CITY OF ALBUQUERQUE

March 22, 2013

**Re: L&C Transport, 8705 Central Avenue NW, Grading and Drainage Plan
Engineer's Stamp date 03-11-2013 (K-09/D037)**

GRADING AND DRAINAGE PLAN

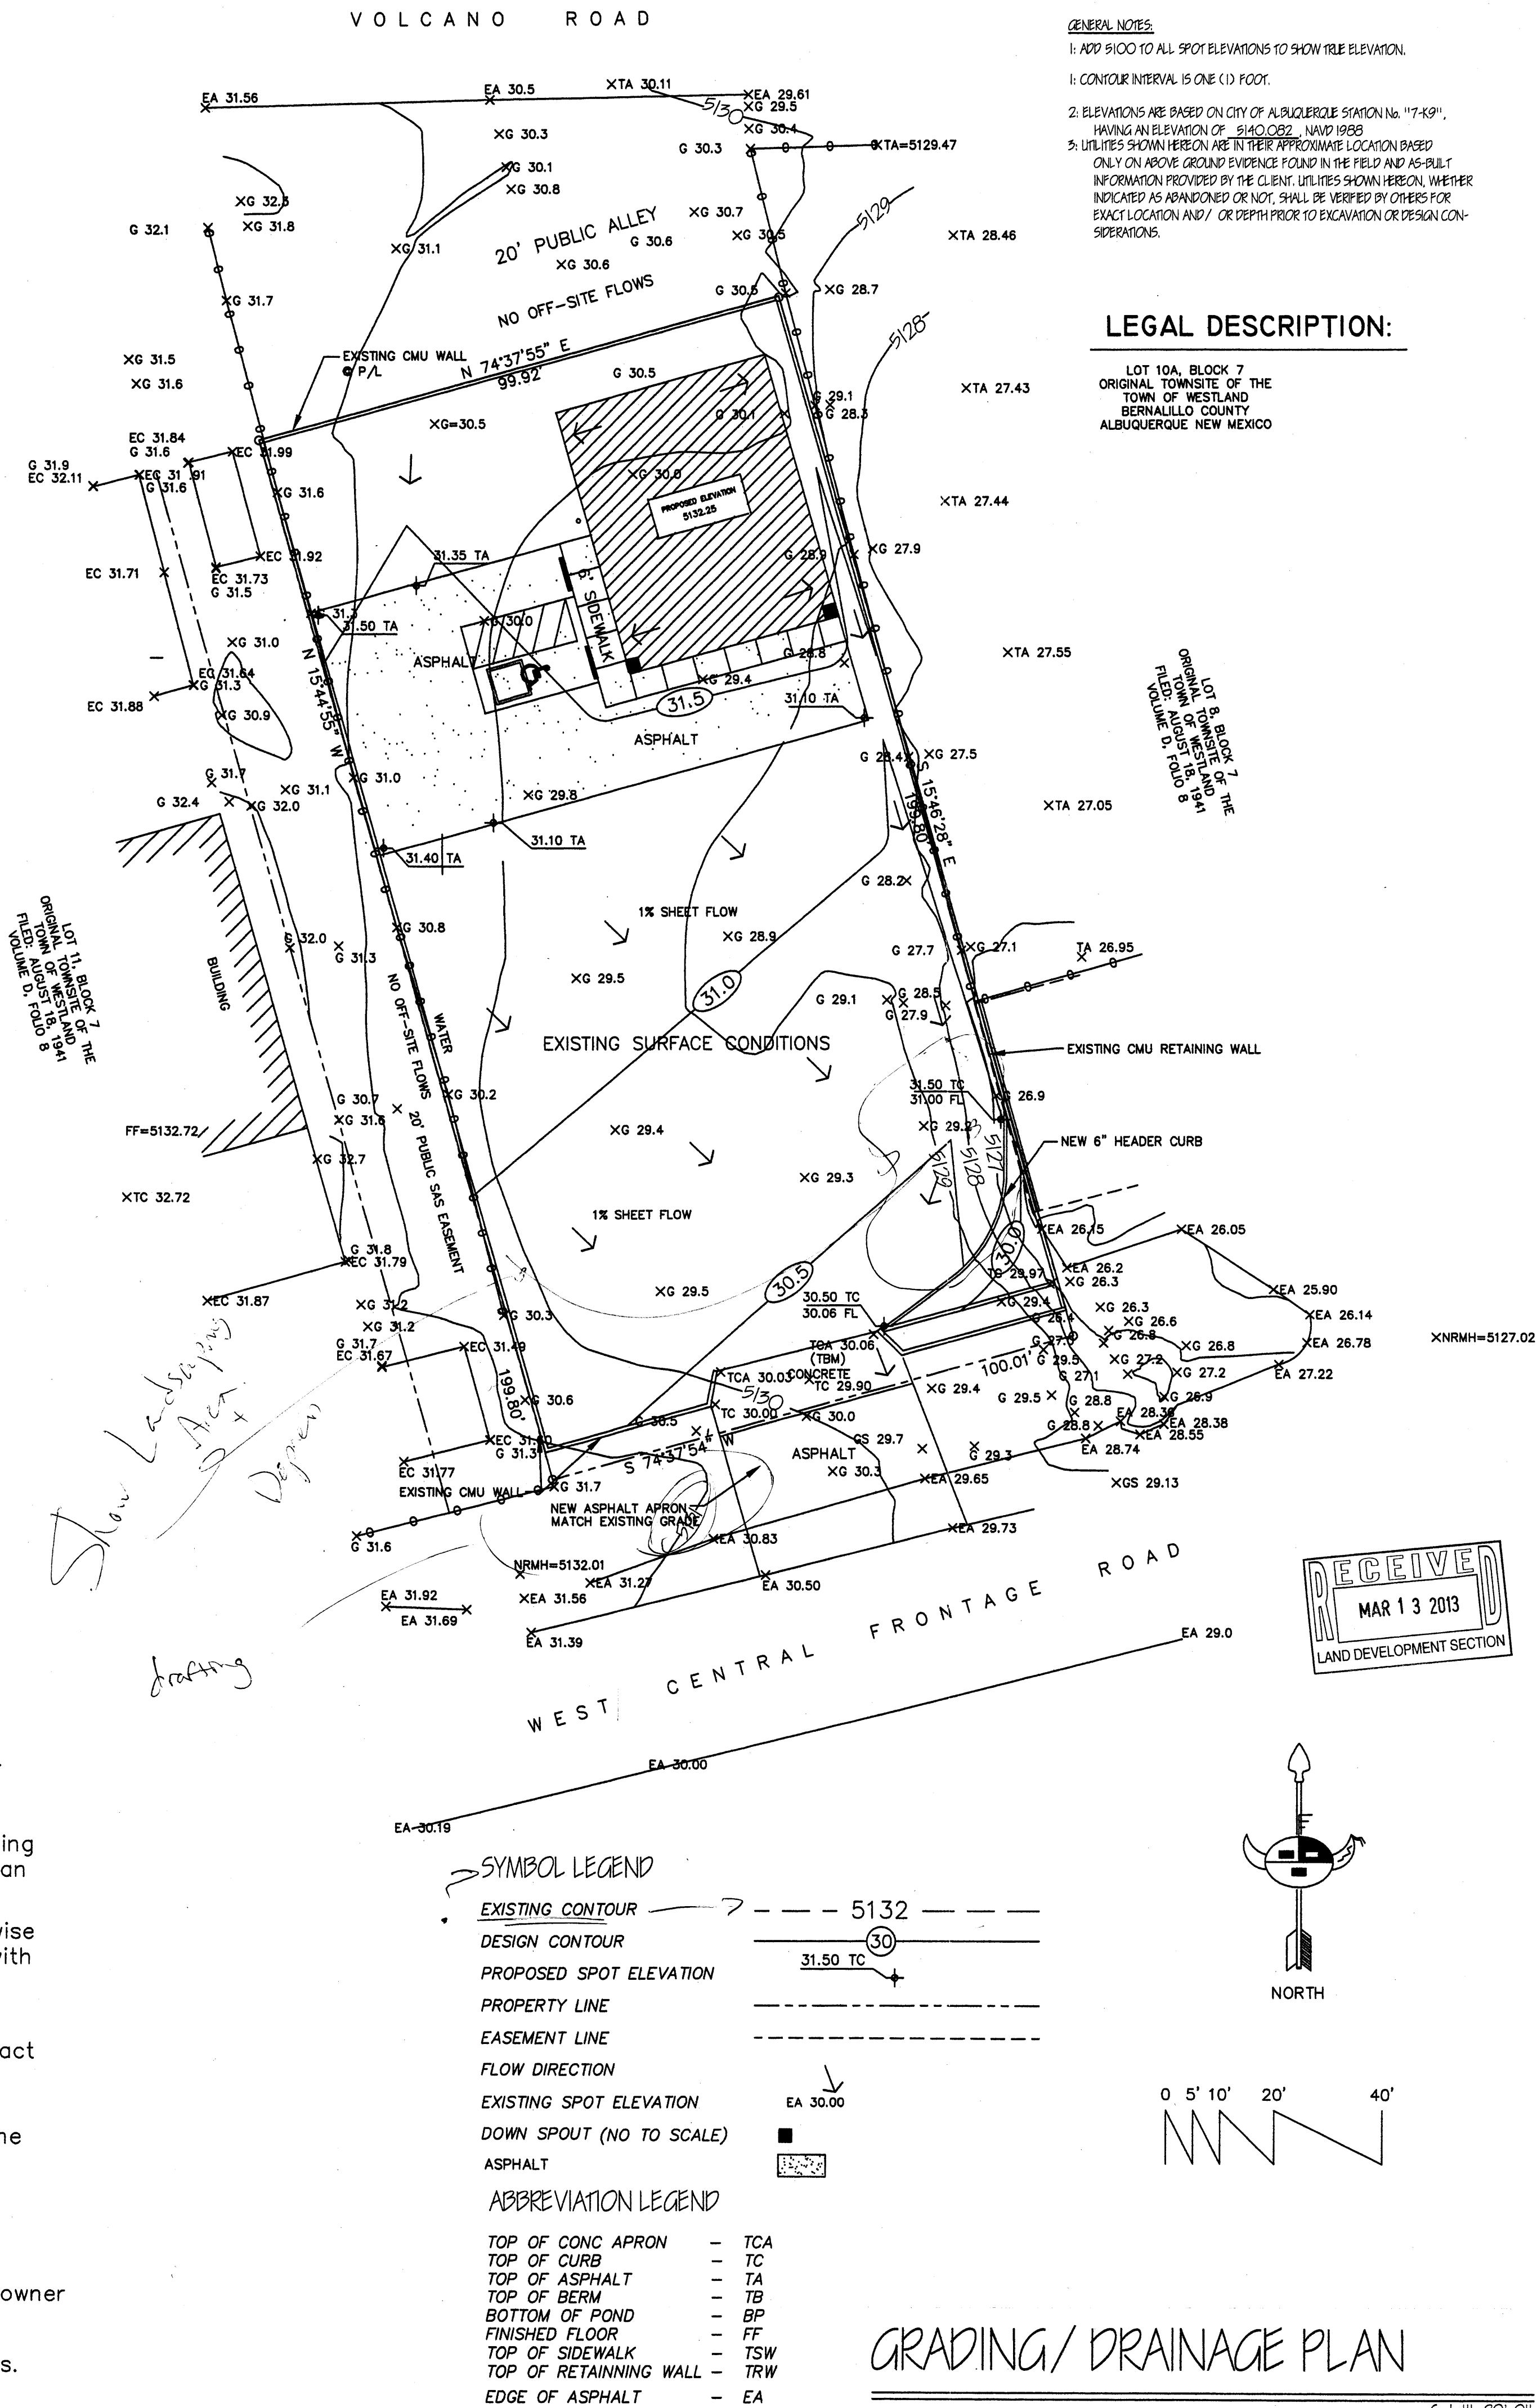
- Show all landscape areas on the plan and depress any landscaping for water harvesting. Clarify how treatment type "B" will increase on the site in its developed condition.
- The legend shows existing contours as dashed lines, however, this is not reflected on the grading plan.
